South Humber Bank Energy Centre

Section 51 Advice – draft Application Documents submitted by EP Waste Management Limited for the Planning Inspectorate (“the Inspectorate”) review

This advice relates solely to matters raised upon the Inspectorate’s review of the draft application documents submitted in December 2019 by EP Waste Management Limited (“the Applicant”), and not the merits of the proposal. The advice given is without prejudice to the acceptance or otherwise of the eventual application.

## FIGURE 1: GAS PIPELINE ROUTE OPTIONS

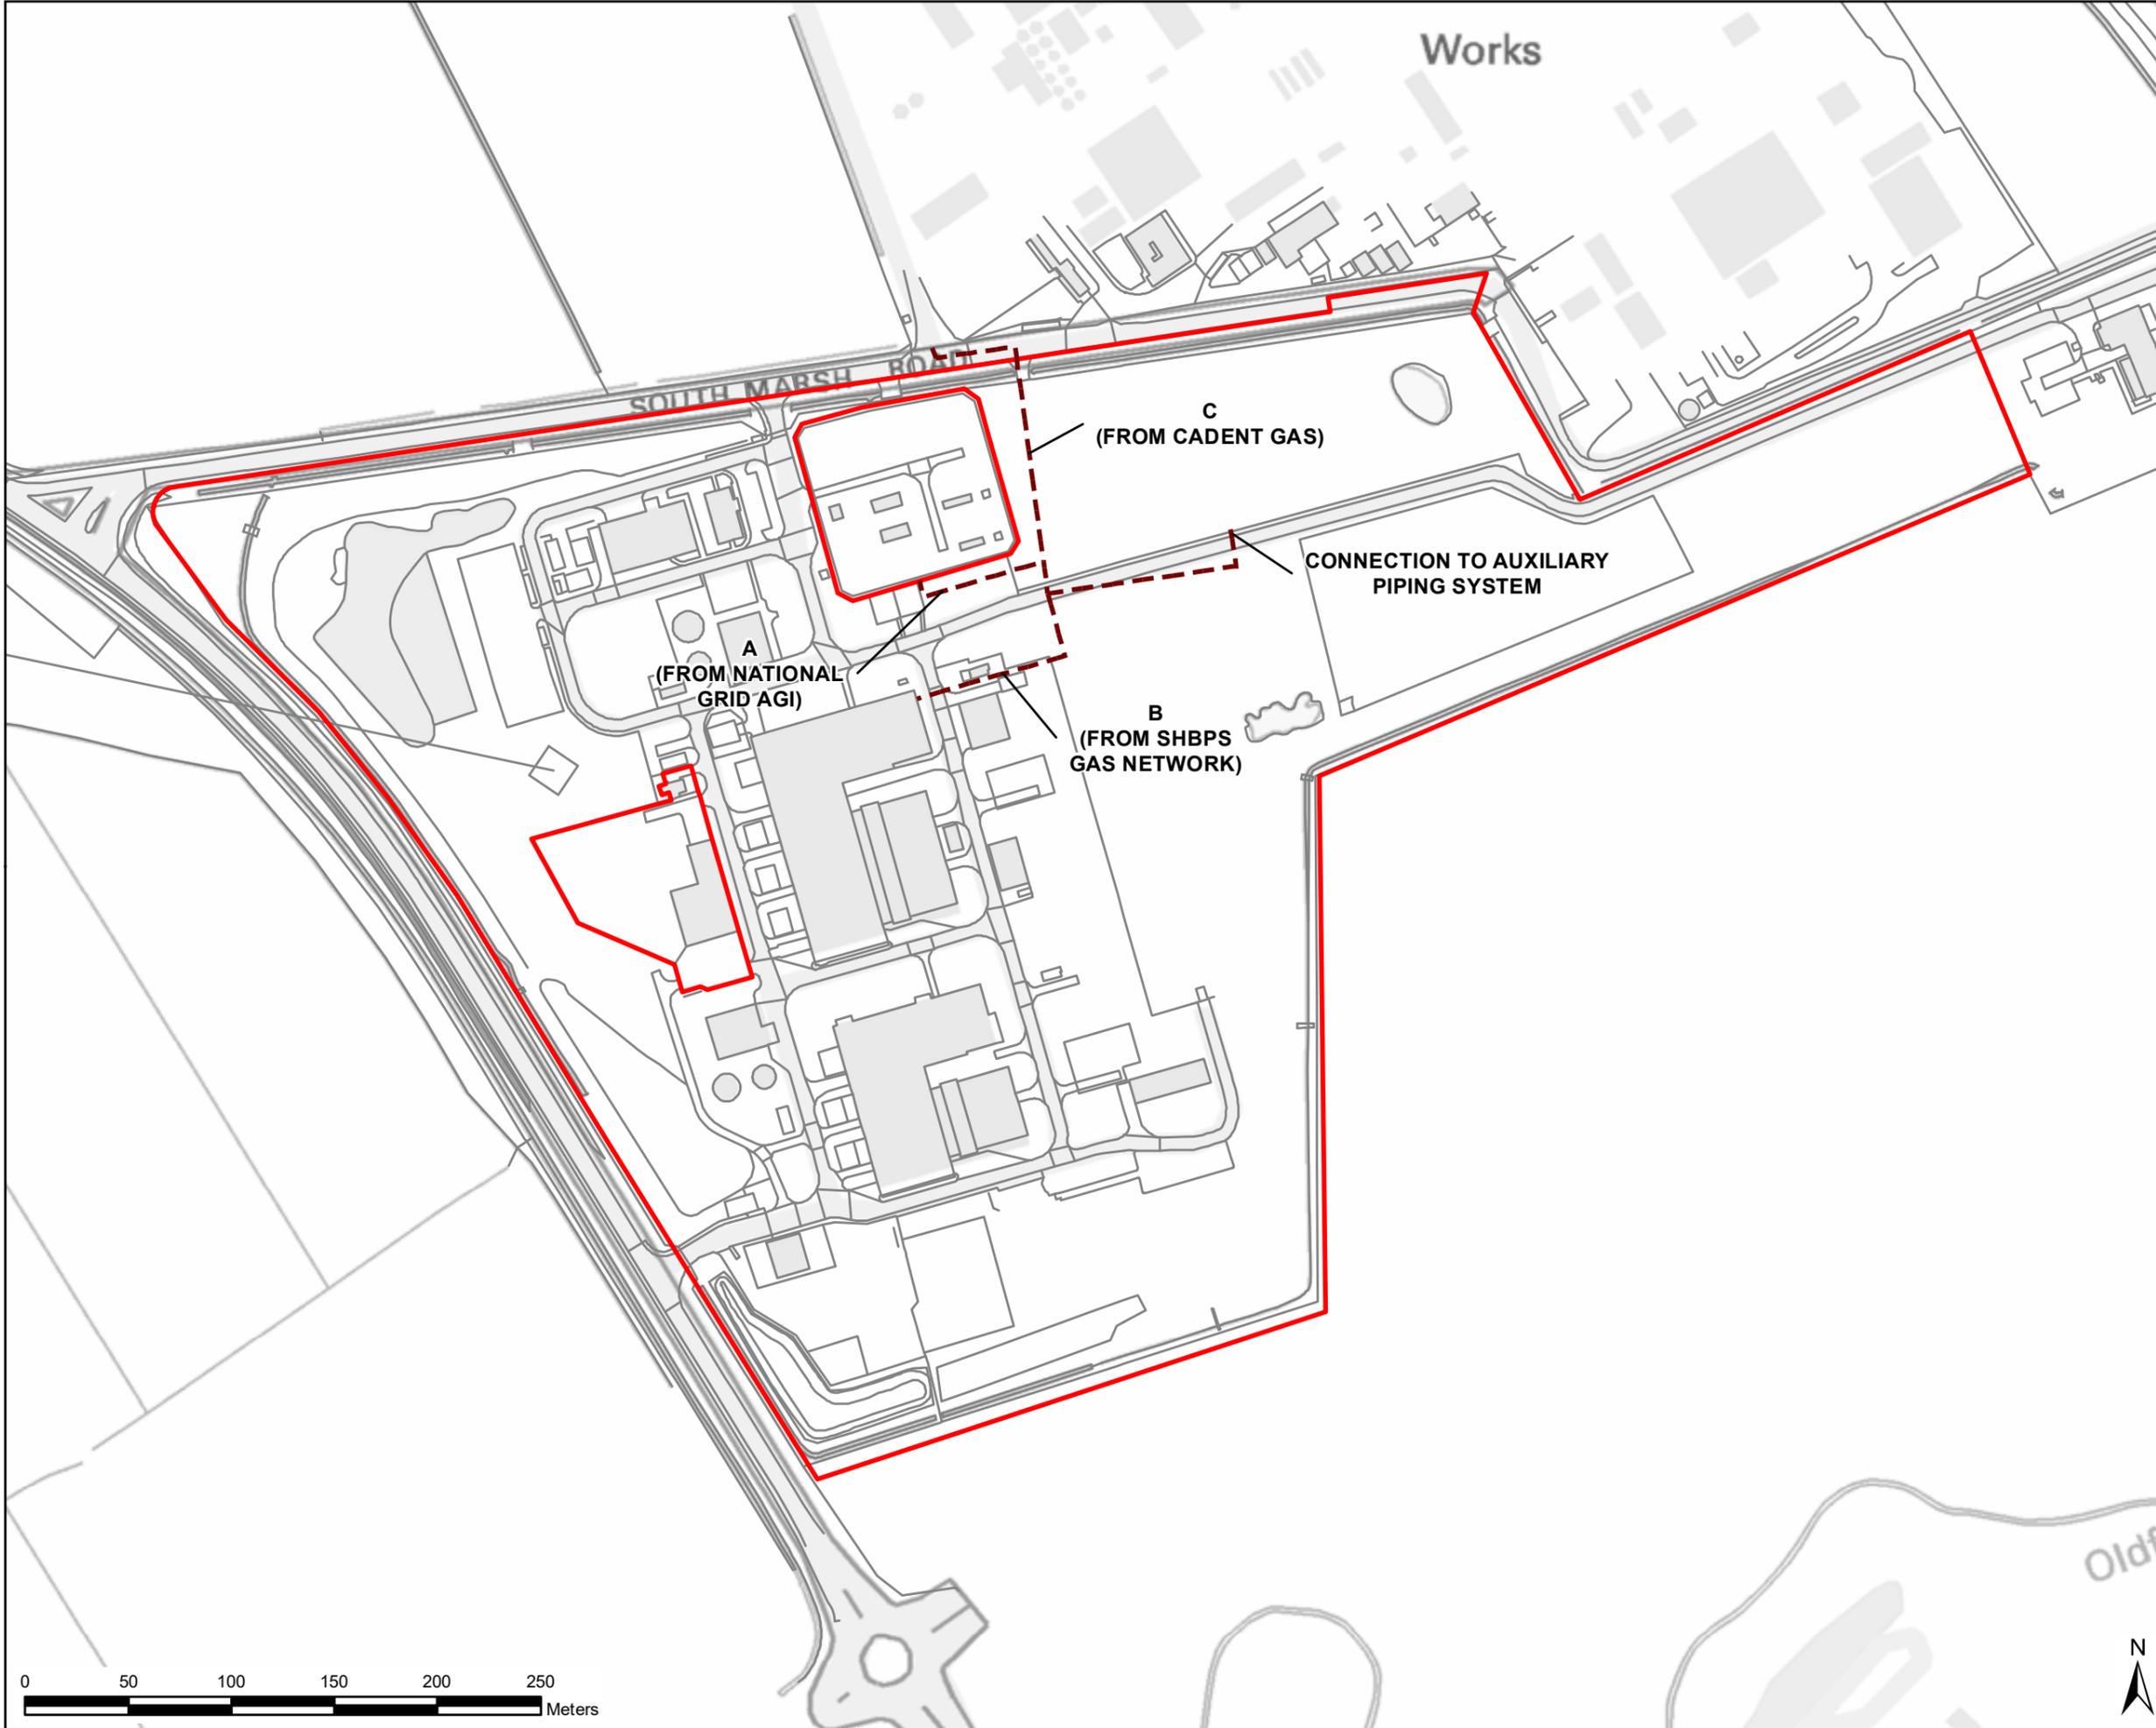
13.	Schedule 1	<p>Work 2</p> <p>The DCO provides for either (a) (an underground or over ground electrical connection) OR (b) (an underground gas supply pipeline). This appears to be a drafting error. If it is not, the Applicant needs to explain this further.</p> <p>In relation to (a) the Applicant should explain when a decision will be made on whether the electrical connection will be underground or above ground. The Applicant should ensure that both connections have been adequately assessed in the ES.</p> <p>In relation to (b) the Applicant should explain when a decision will be made on whether the gas supply will be to the National Grid distribution network or a local distribution network. The Applicant should ensure that both connections have been adequately assessed in the ES.</p> <p>Further Development</p> <p>The Applicant should consider drafting which ensures that all further development (a) – (j) falls within the scope of works assessed in the ES.</p>
